Freedom Forever
Planset Revision Letter

11/12/2024
REV #2

SHATACA HICKS
237 BEACON HILL ROAD, LILLINGTON, NC 27546

JOB NO:	DATE:	DESIGNED BY:	SHEET:
498387	11/12/2024	A.N.	PV-1

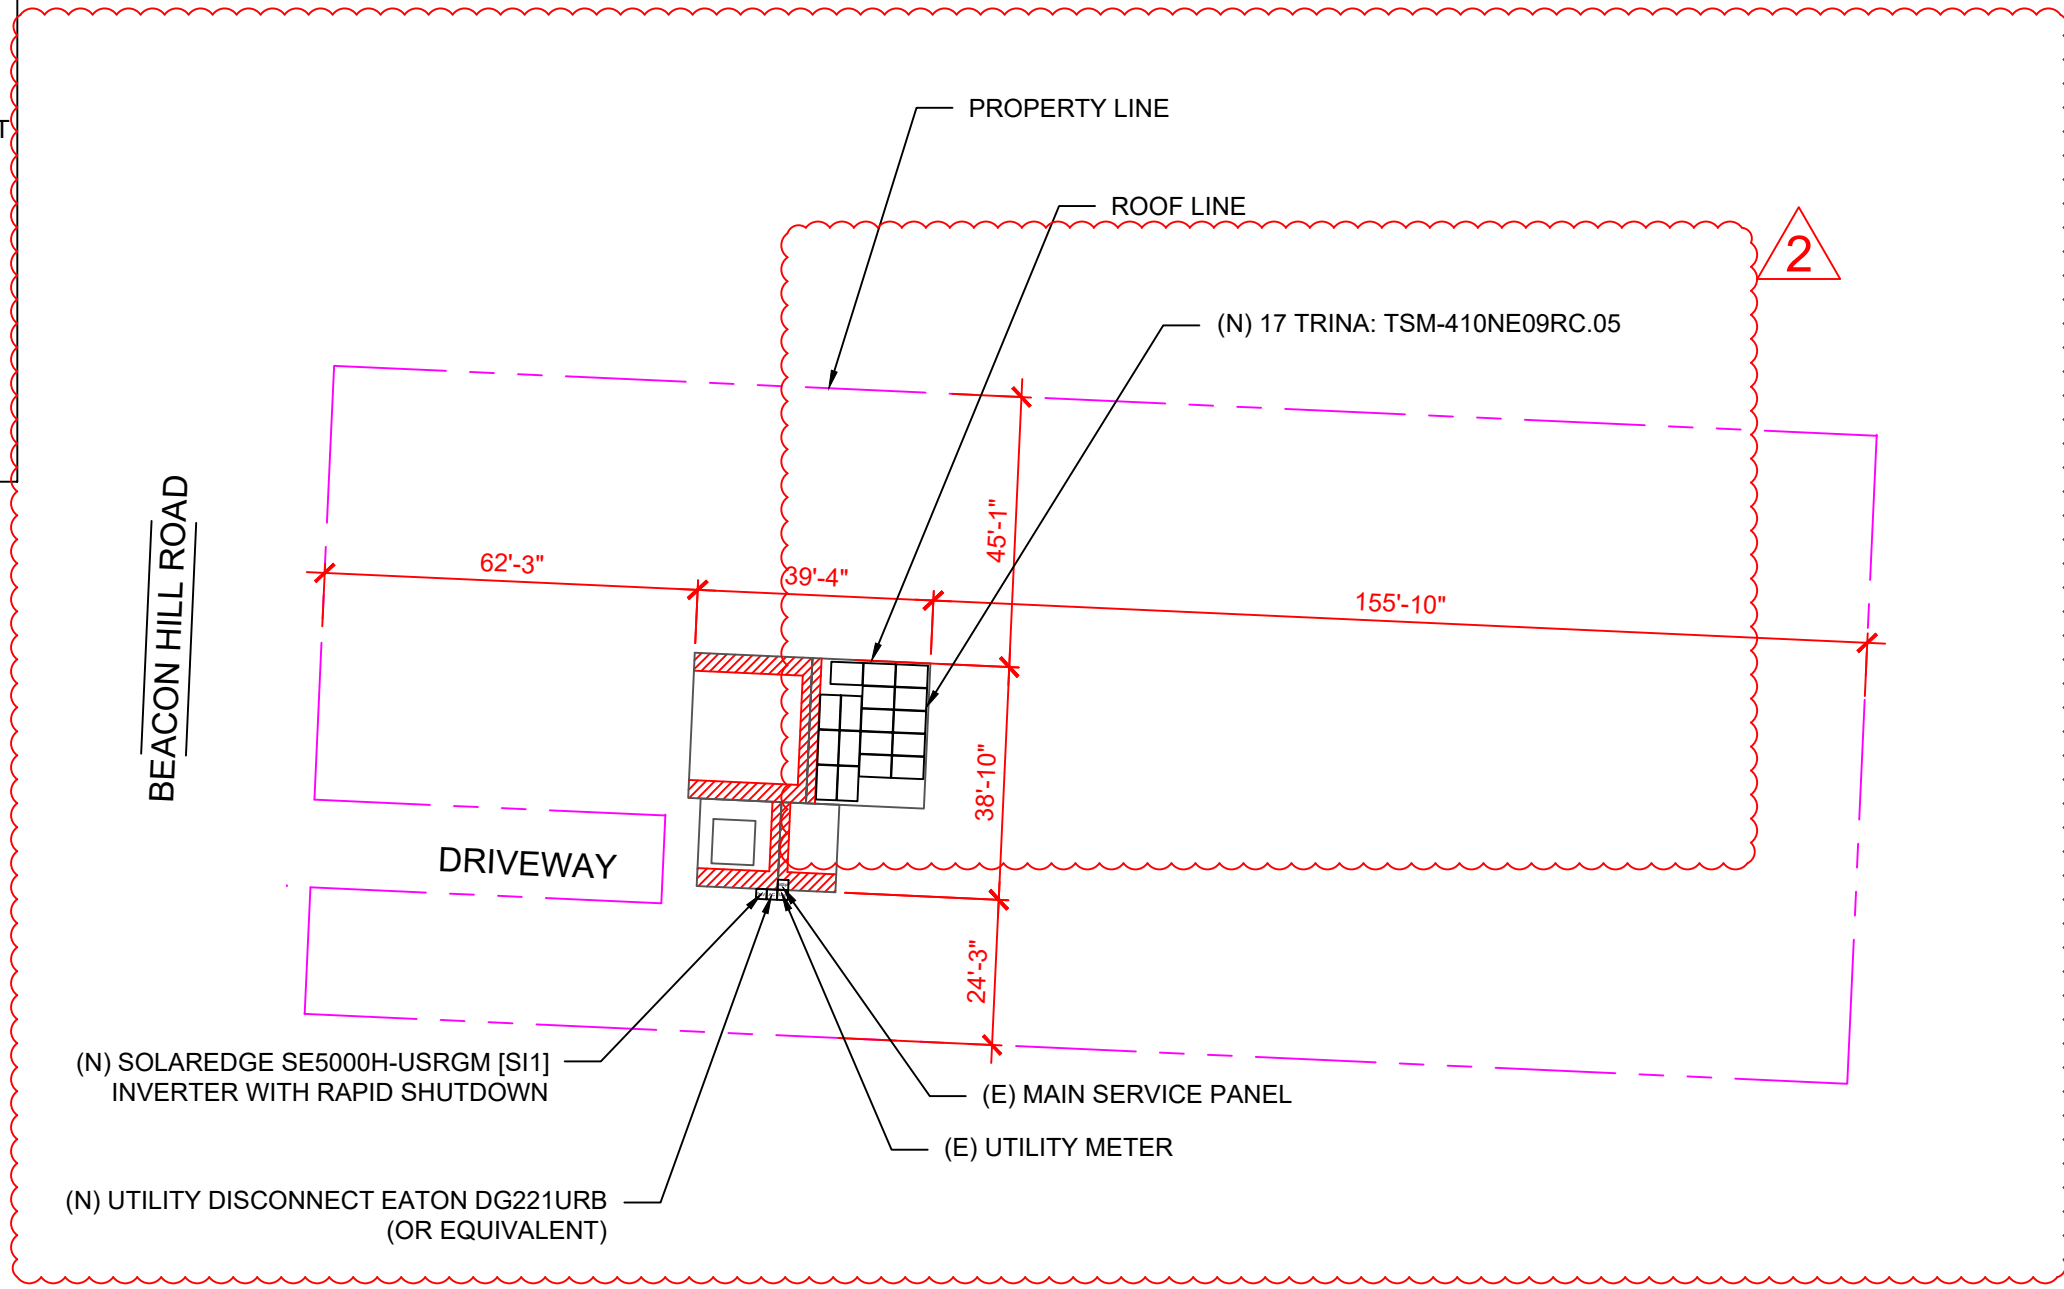
REV#1

Module swapped to Silfab 430 to Trina 410

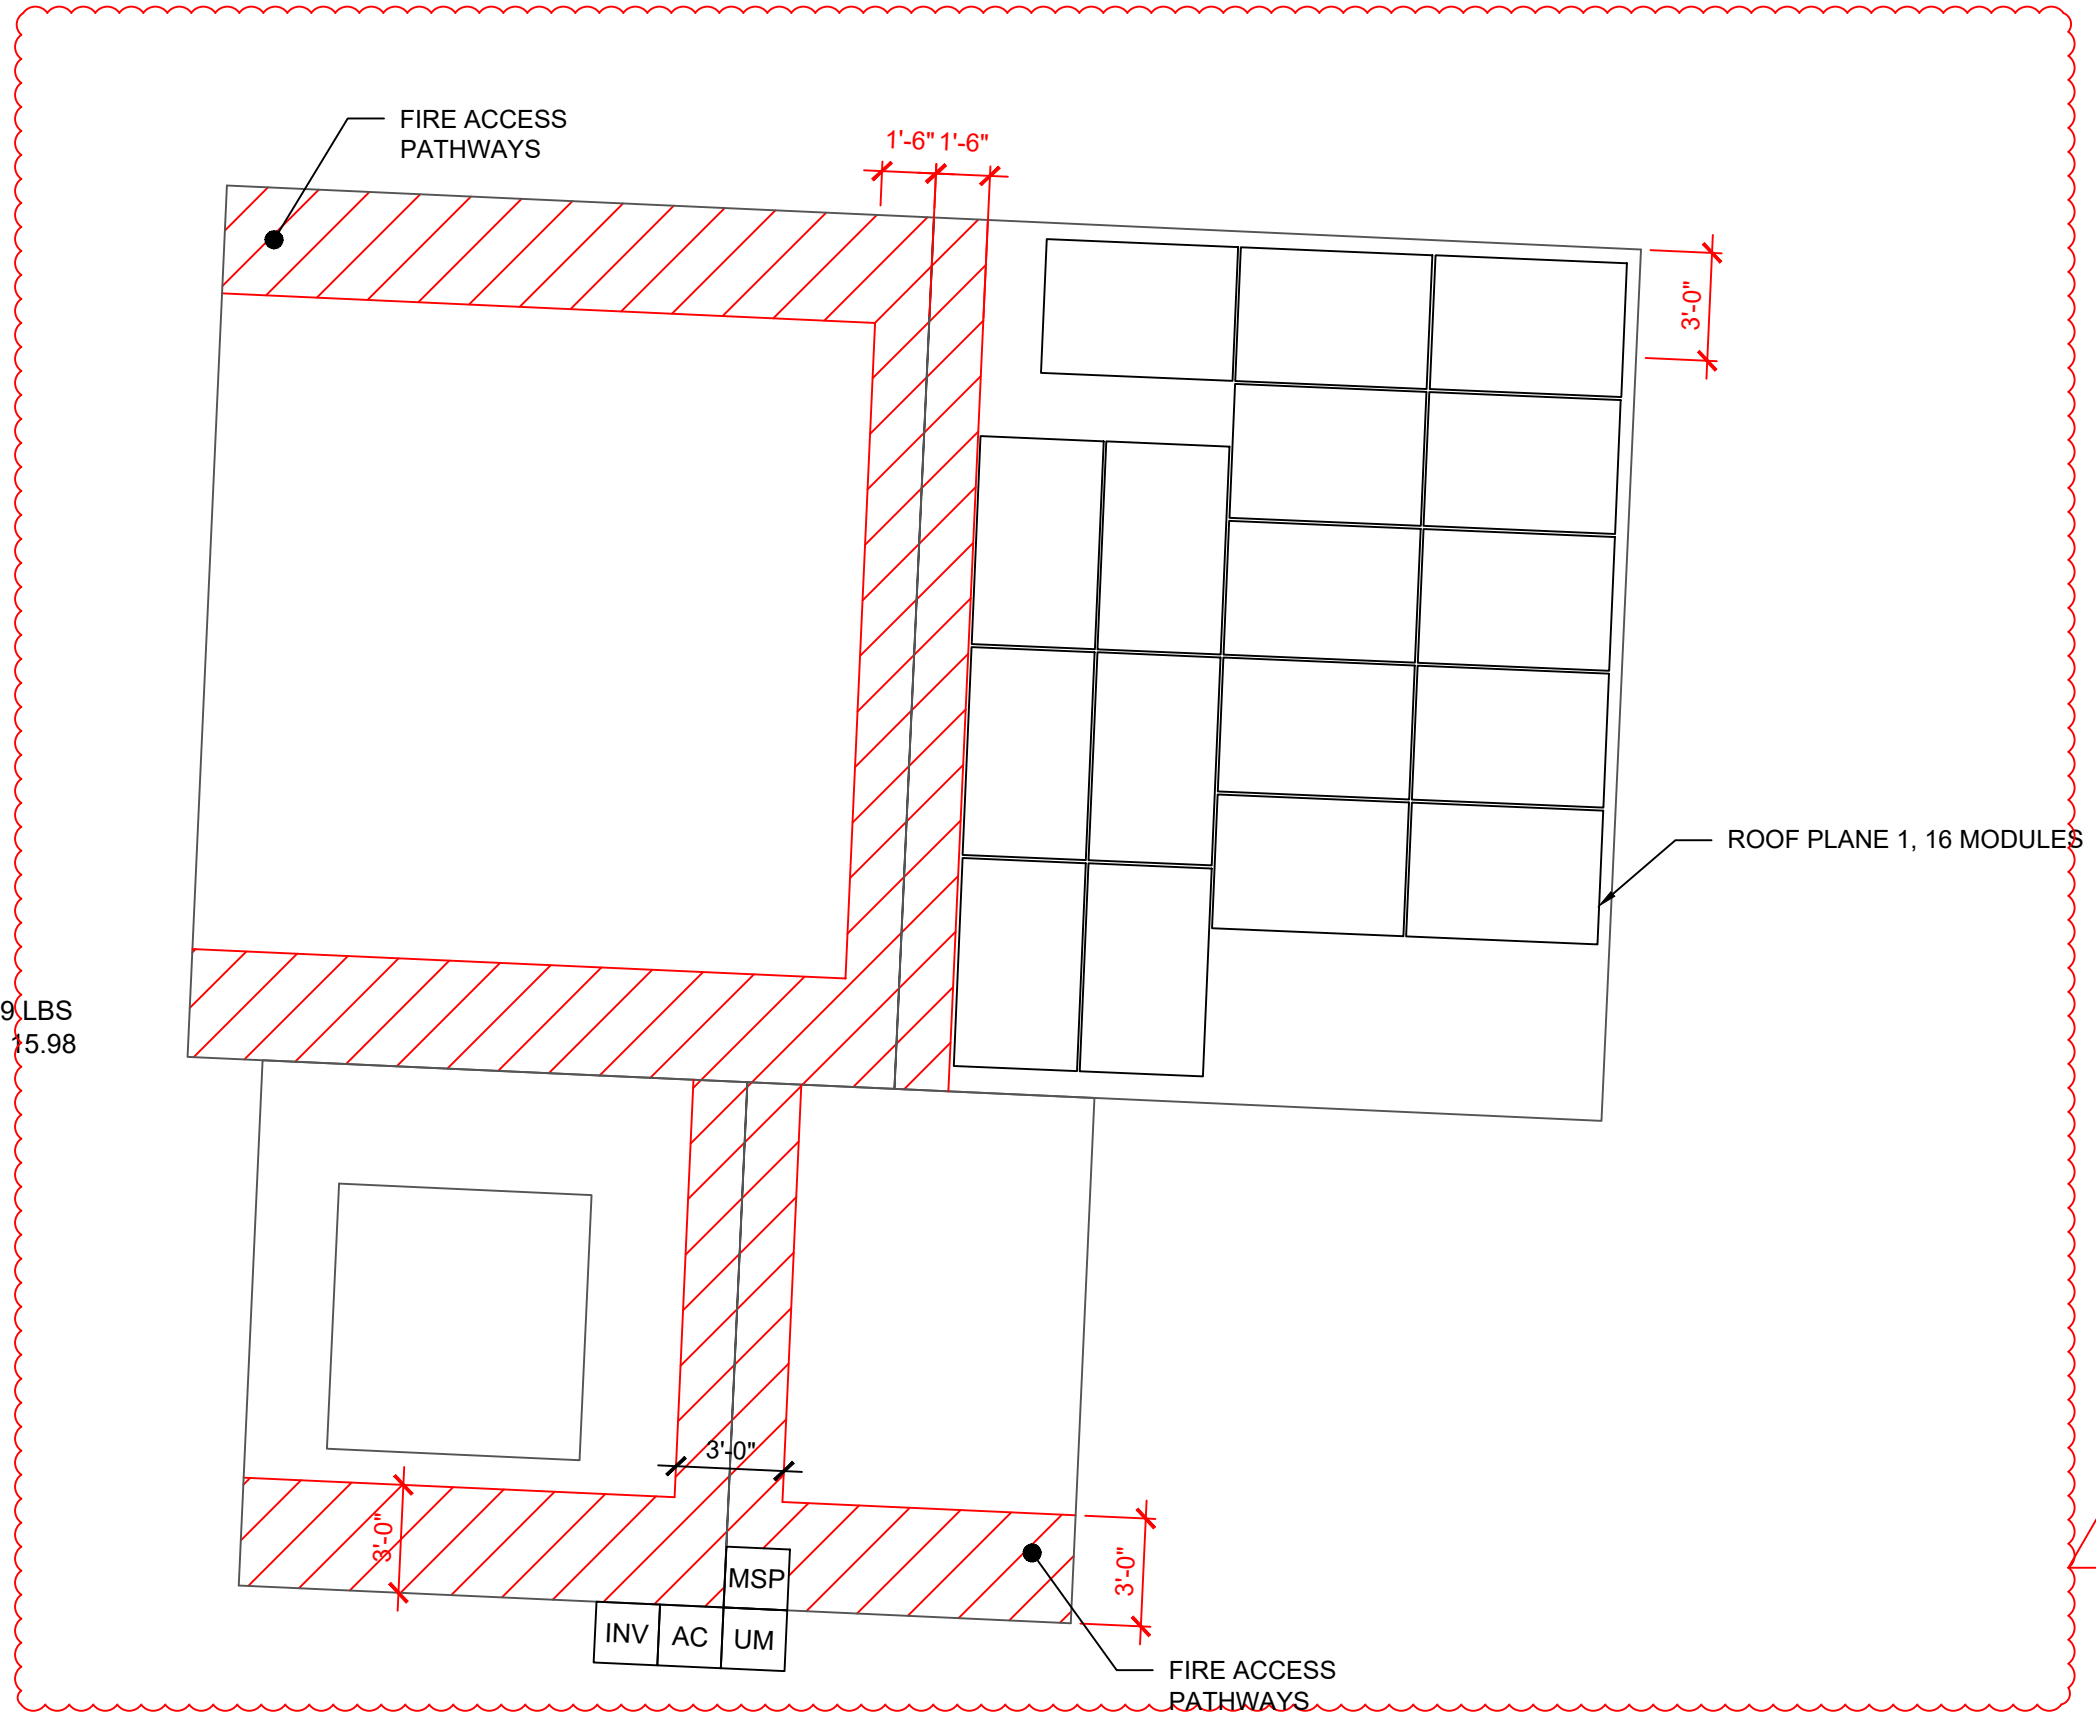
REV#2

Layout changed to match installed layout
